DELEGATED HOUSEHOLDER DECISION

Item No.	Report of the Head of Development Management and Building Control		
Address:	79 HALFORD ROAD ICKENHAM		
Development:	Erection of a part single, part double storey extension to the rear/side, conversion of roof to habitable use to include, double hip to gable roof extension with 1no side and 1no rear dormer, roof lights and new gable end windows, following the demolition of existing conservatory and garage		
LBH Ref Nos:	43170/APP/2025/462		
Drawing Nos:	103 REV 4 E201 REV 4 E202 REV 4 102 REV 4 105 REV 2 101 REV 4 PP-13776506v1		
Date Plans received:	24-02-25	Date(s) of Amendments(s):	01-04-25
Date Application valid	24-02-25		01-04-25 01-04-25 01-04-25 01-05-25 01-04-25

Erection of a part single, part double storey extension to the rear/side, conversion of roof to habitable use to include, double hip to gable roof extension with 1no side and 1no rear dormer, roof lights and new gable end windows, following the demolition of existing conservatory and garage

DRAWING NO. E201
PROJECT NO: 01
DATE: 04/01/2025

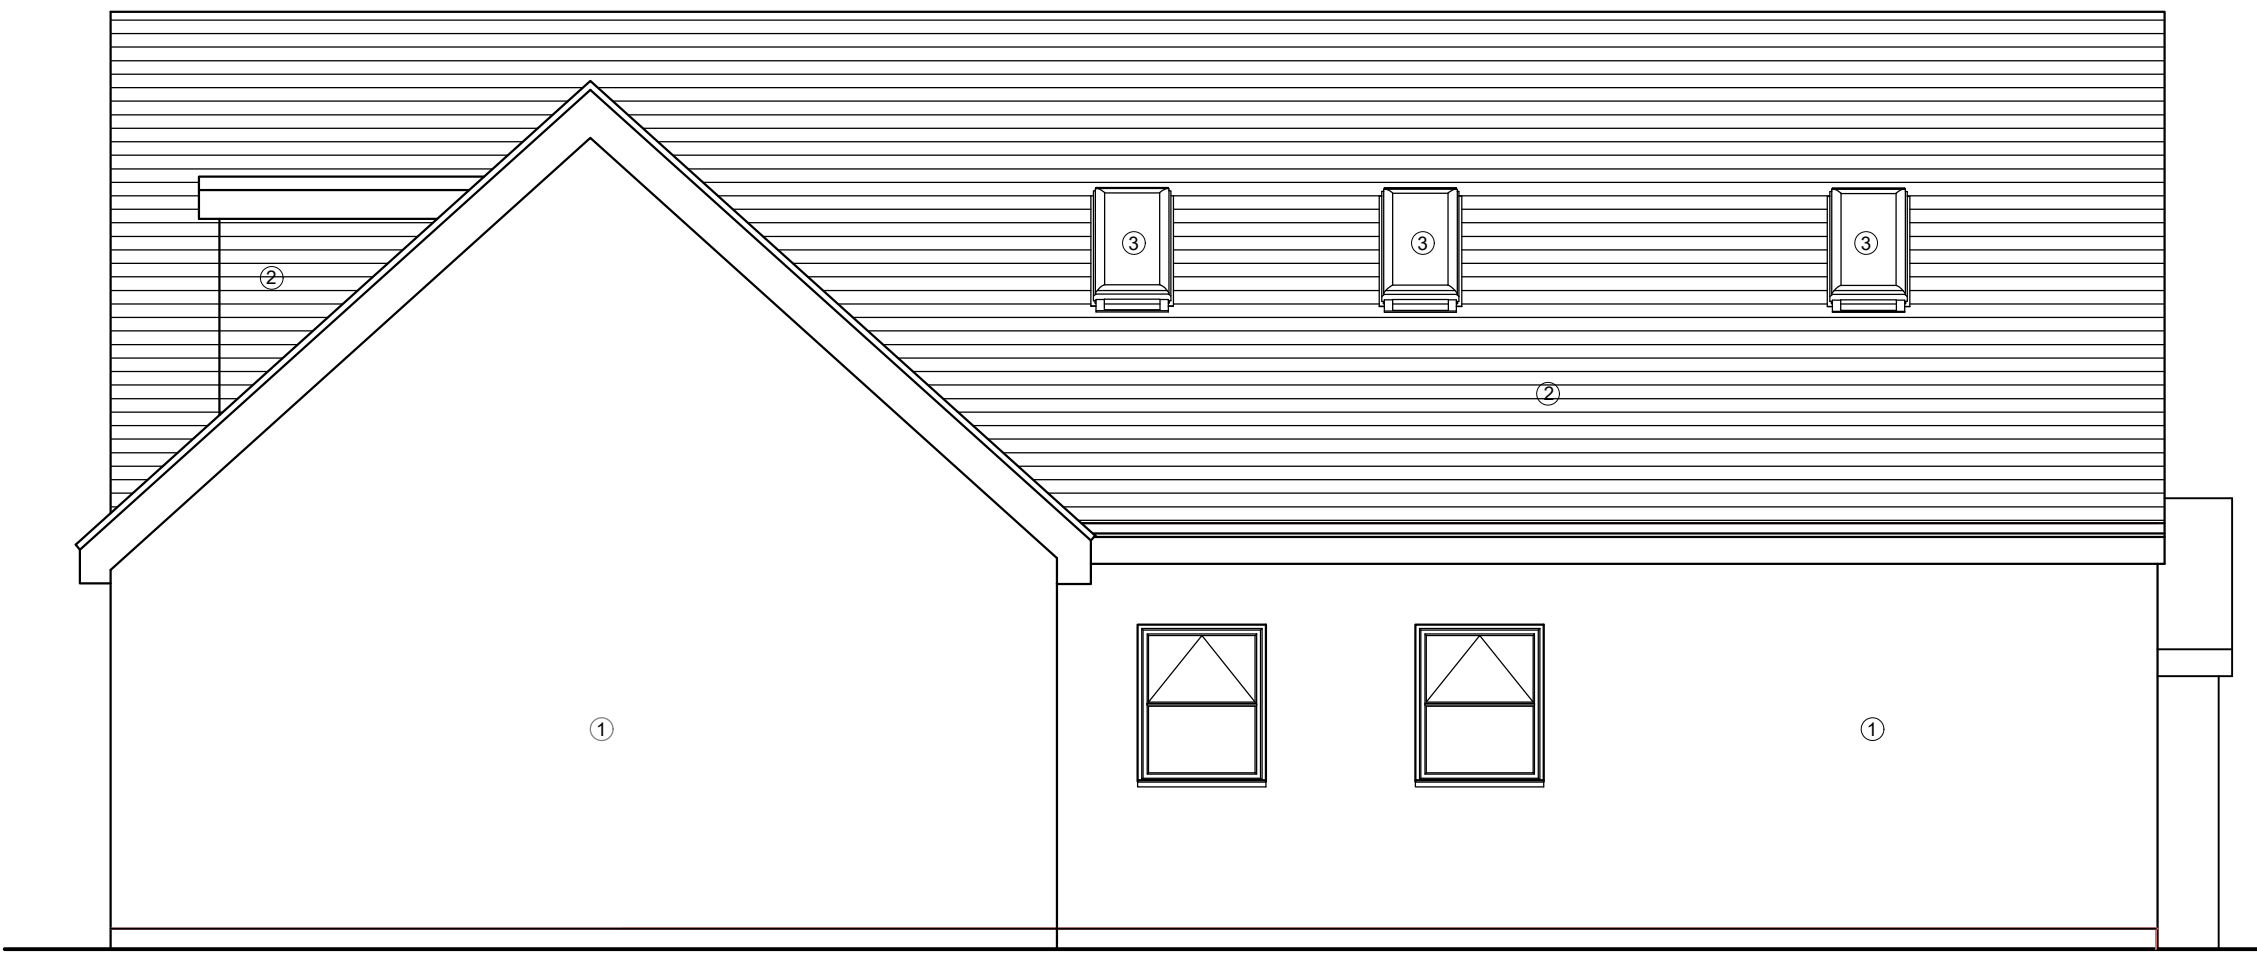
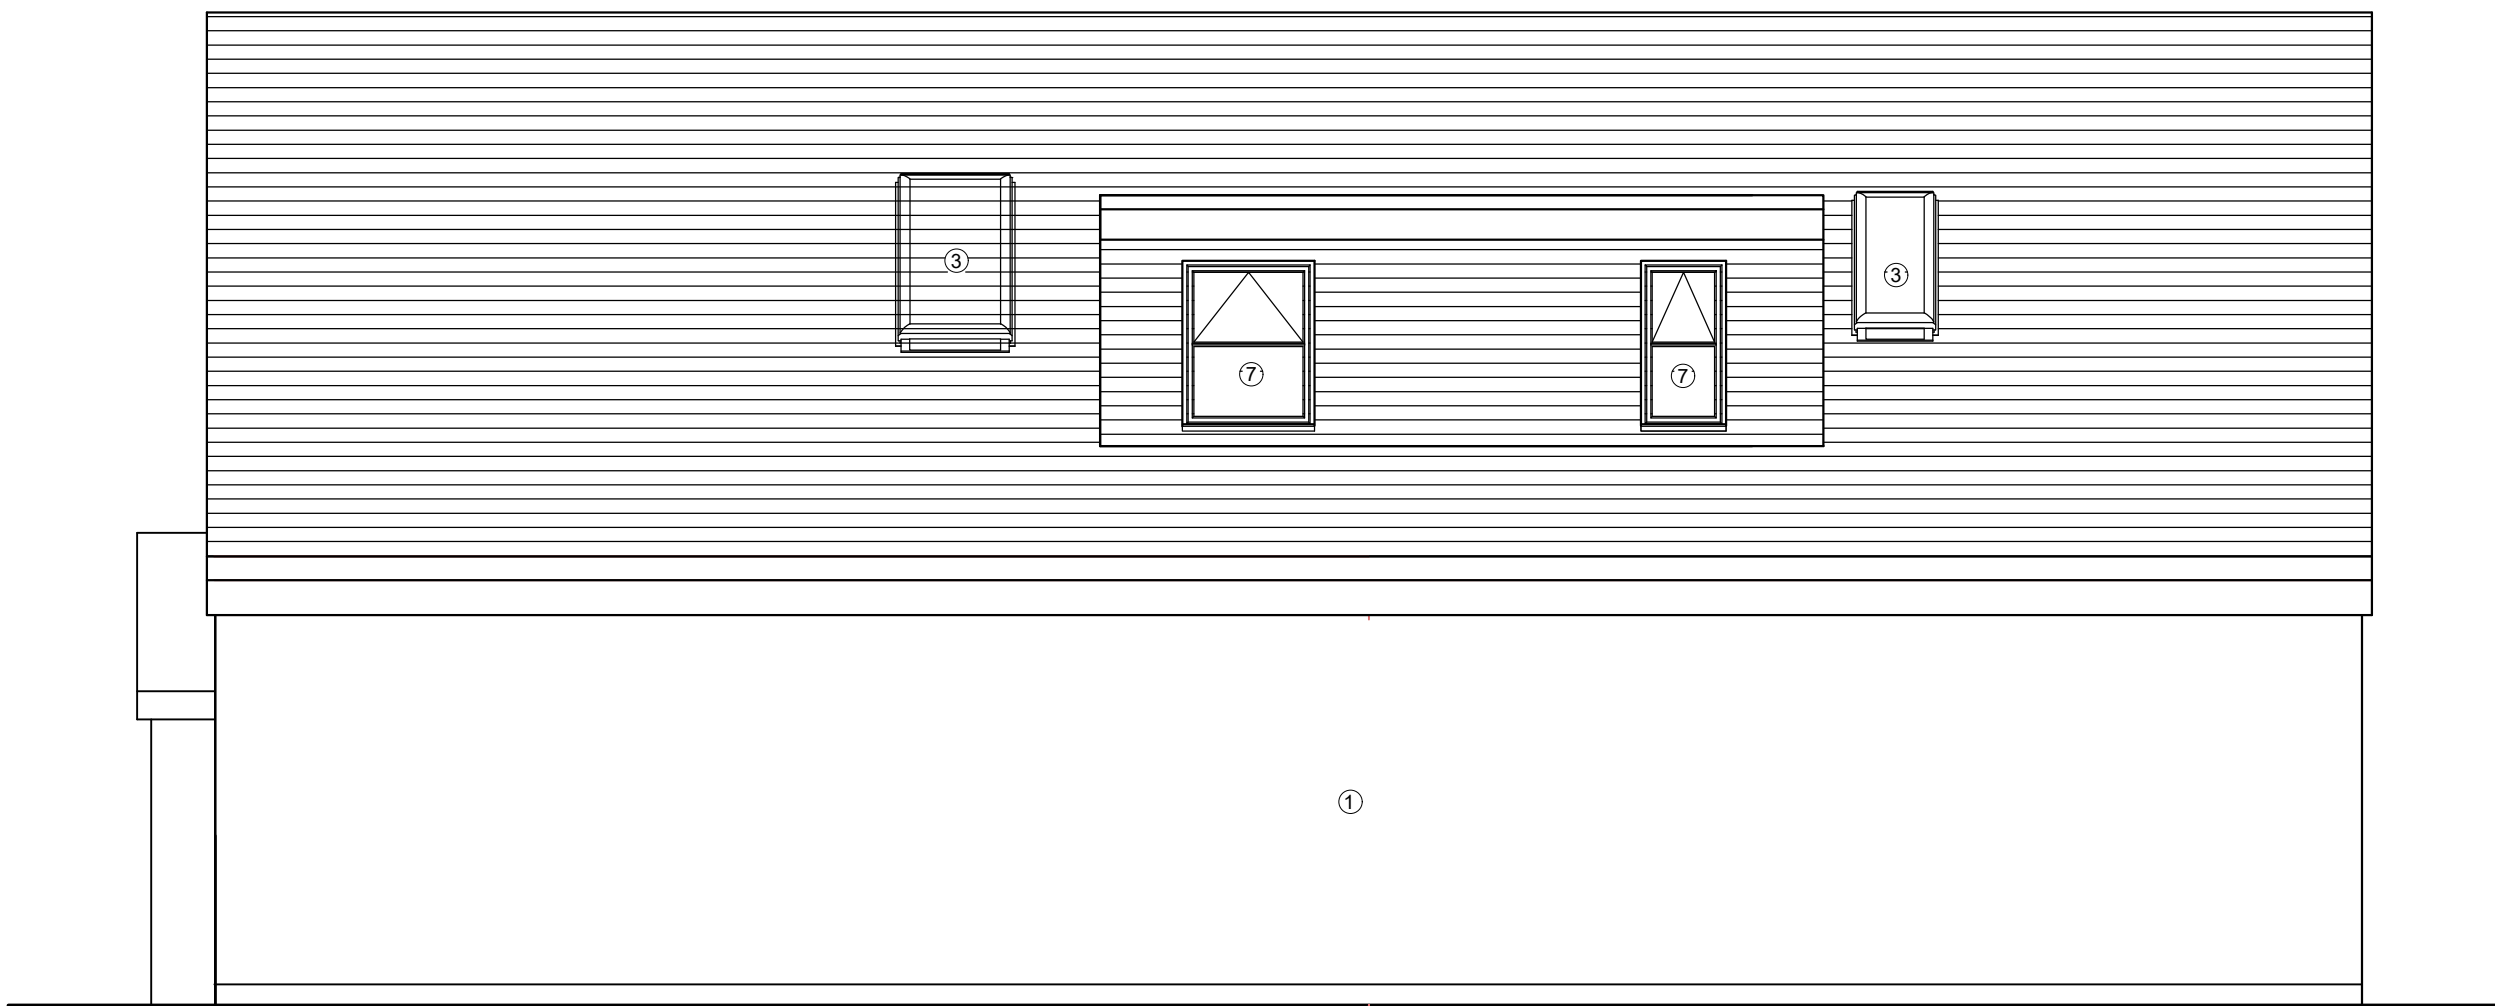
The proposal maintains a similar height to neighbouring properties, marginally lower than No. 75.

The side addition is set back to ensure it remains subordinate and reduces the bulk. The proposed

dwelling would maintain similar frontage as the existing property, and would be slightly behind the existing building line. To the rear the proposed rear elevation would be deeper than existing, however, offers a staggered depth when compared with neighbouring dwellings and would be comfortably sited outside of the 45 degree sight lines at ground and first floor.

Number 81 benefits from side windows at ground floor which according to planning history serve a shower room/utility. The proposed rear extension would not breach the 45 degree sight lines and would project approx. 3m past the rear elevation. The side windows would be conditioned to be obscured glazing and non-opening below 1.8m in the event of an approval. Taking these factors into account it is considered that the proposal would not adversely effect the amenities of neighbouring occupiers of No.81.

Number 77 benefits from a single storey rear extension which projects beyond the proposed extension. In addition, No.77 has three side facing windows. The larger window is a secondary window to the front bedroom. The smaller two windows serve the dining room which does not benefit from another window. Revisions were sought to reduce the depth of the side extension to ensure that one window to the dining is not obstructed. In addition, the side extension is set over a 1.3m off the boundary. The ground floor side window will be conditioned to be obscurely glazed given it is a secondary window to the ground floor bedroom. The revisions have overcome previous concerns which were raised in application ref. 43170/APP/2024/1029.

The side windows and side roof lights facing both 77 and 81 Halford Road shall be glazed with permanently obscured glass to at least scale 4 on the Pilkington scale and be non-opening below a height of 1.8 metres taken from internal finished floor level for so long as the development remains in existence.
